From: Rebecca Bowers
Sent: 29 October 2020 10:01
To: Tara Thompson
Subject: FW: 33 Littlemoor Road Clitheroe 3/2020/0754

From: Bloomer, David <David.Bloomer@lancashire.gov.uk>
Sent: 29 October 2020 09:54
To: Rebecca Bowers <Rebecca.Bowers@ribblevalley.gov.uk>
Subject: RE: 33 Littlemoor Road Clitheroe

Proposed Ground Floor Plan

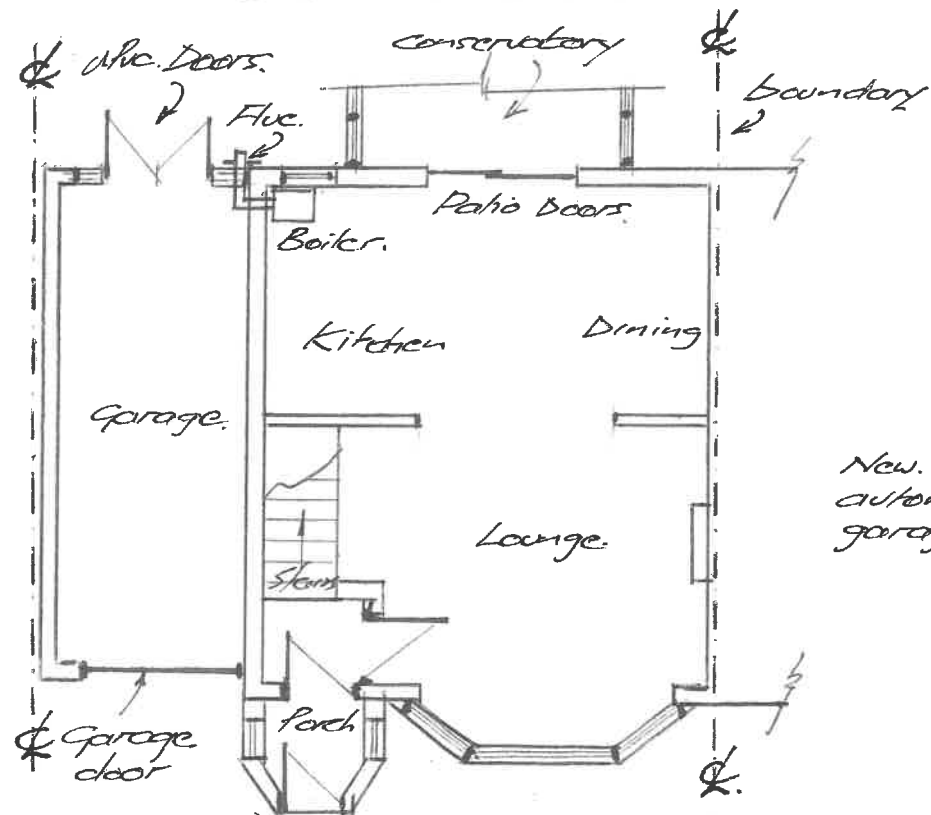
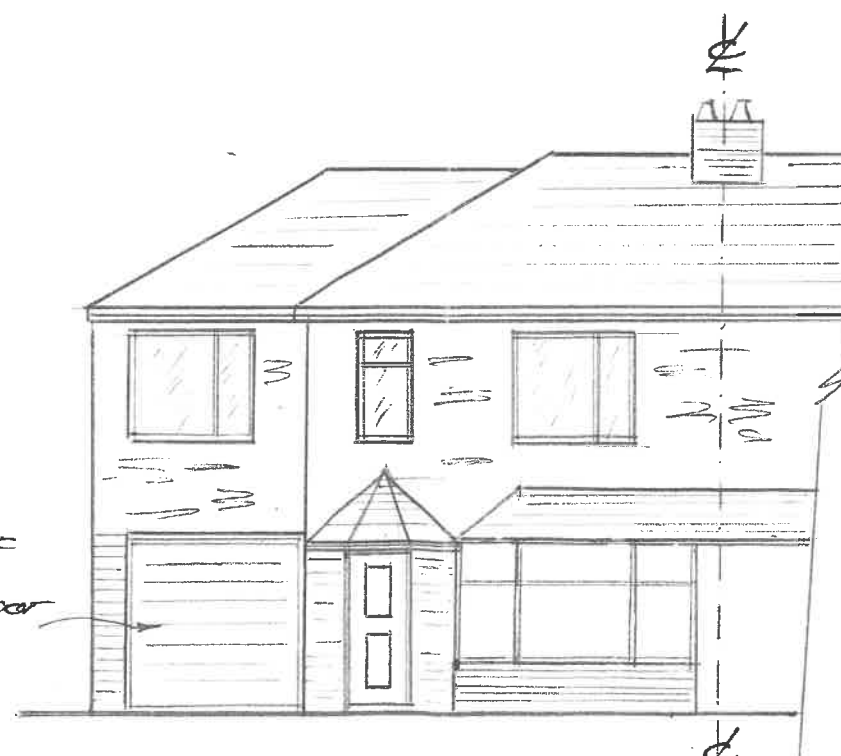
Although it would be tight, it would be difficult to argue that the addition of the garage door would prevent its use as a garage and in the absence of any increase in the parking requirements for the property as a result of this application, I would raise no objection to the proposal on highway grounds.

The garage door measures 2.2 metres and the depth of the garage is 6.5m
